KIRKLEES METROPOLITAN COUNCIL INVESTMENT & REGENERATION SERVICE

DELEGATED DECISION TO DETERMINE PLANNING APPLICATIONS

Reference No:	2025/62/90735/W
Site Address:	87, New North Road, Edgerton, Huddersfield, HD1 5ND
Description:	Erection of two storey side extension, hip to gable alteration and rear dormer (within a Conservation Area)
Recommending Officer:	Molly Storer

DECISION – CONDITIONAL FULL PERMISSION

SHEET 02

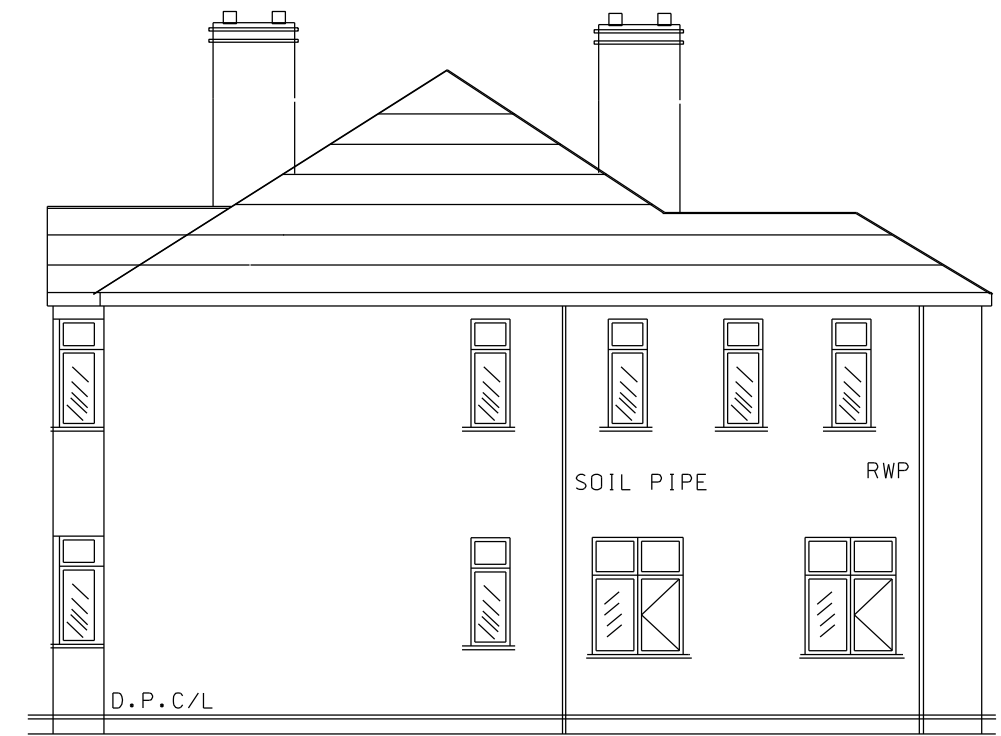
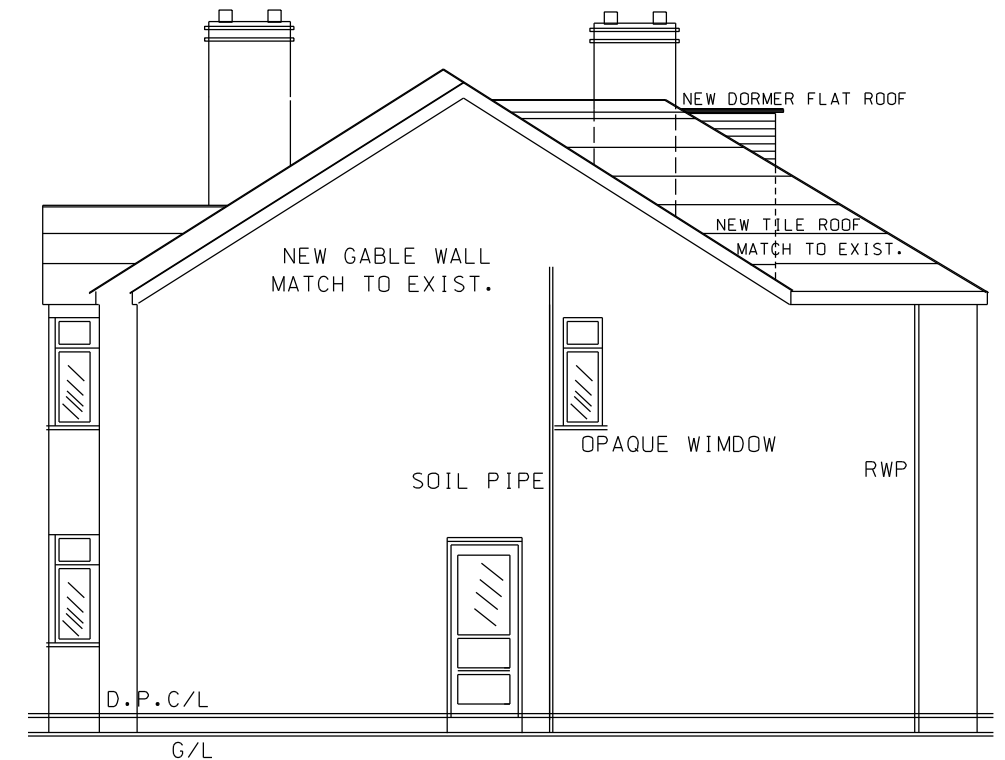
The rear dormer would be small in scale and would be set well within the confines of the existing roof. It will be set down from the ridge and above the eaves, with space of the original roof retained to the sides. The dormer is designed with a flat roof, and the front and cheeks of the dormer will be conditioned to be tile hung to match that of the existing roof and to be of a dark grey colouring.

A dark grey colour will not directly match the colouring of the existing roof however this is considered acceptable as the existing appears to be rosemary tiles but this colouring has worn away. Therefore, a dark grey colouring for the dormer would not detrimentally contradict with the roof slope.

It is noted that there are a number of other, similar extensions in the area and some of these historic properties do have smaller scale dormers. The dormer is therefore considered to be acceptable in terms of visual amenity. It is recommended any grant of permission requires the walls of the dormer to be of a dark grey colour finish.

The extension would be set well back from the highway and from the front wall of the house by 500mm. Due to this, the development would not appear overly prominent from public vantage points. The ridge is set down from the host property to ensure a subservient appearance that does not over dominate the original house. It would not project beyond the rear the host property and a large amount of private outdoor space for occupiers of the dwelling would be retained to the rear of the property.

It is noted that a 1m gap would not be maintained from the boundary however from a visual perspective it is noted that the adjacent property to the northwest and the host property are two distinct property types. Due to these differences in property type and the differing levels of the properties (whereby the neighbouring property is located on a higher ground level) it is considered that this will provide a sufficient visual break between the dwellings and it would be unreasonable of the LPA to require this in this instance. It is considered the fact a 1m gap to the boundary is not provided would not constitute a reason for refusal which could be substantiated in this instance.

With regard to the two storey side extension, this will create additional massing closer to the boundary with No.89. However it is noted that this element will face a mostly blank elevation at the ground floor level of No.89 with only a single door in this elevation. The nearest windows are located on the first floor at a separation distance of ~4m. Given the relationship between these buildings whereby No.89 is located on a higher ground level and the size / scale of the proposal, it is concluded the impact in terms of overshadowing / oppressiveness to No.89 would not be so significant as to warrant refusal. The windows to no.89 appear to serve non habitable rooms from analysis of the planning history of no.89 and floor plans submitted for previous applications at that property (applications refs 2019/93042 & 2020/90466).

With regards to privacy, the plans show that there would be a single window on the first floor facing in the direction of this property. However, plans show that this window would serve a bathroom and would be opaque to maintain privacy. The only other opening on this elevation is a single door on the ground floor which would not cause significant levels of overlooking. Therefore, it is considered that there will be no significant level of overlooking arising from the development.

2. The walls of the dormer to rear shall be of a dark grey colour finish, and be retained thereafter.

3. Notwithstanding the plans submitted the materials of construction used in the construction of; (i) the walls and roofs of the two storey side and (ii) the hip to gable enlargement hereby approved shall, in all respects, match those used in the construction of the walls and roofs of the existing building and be retained thereafter.
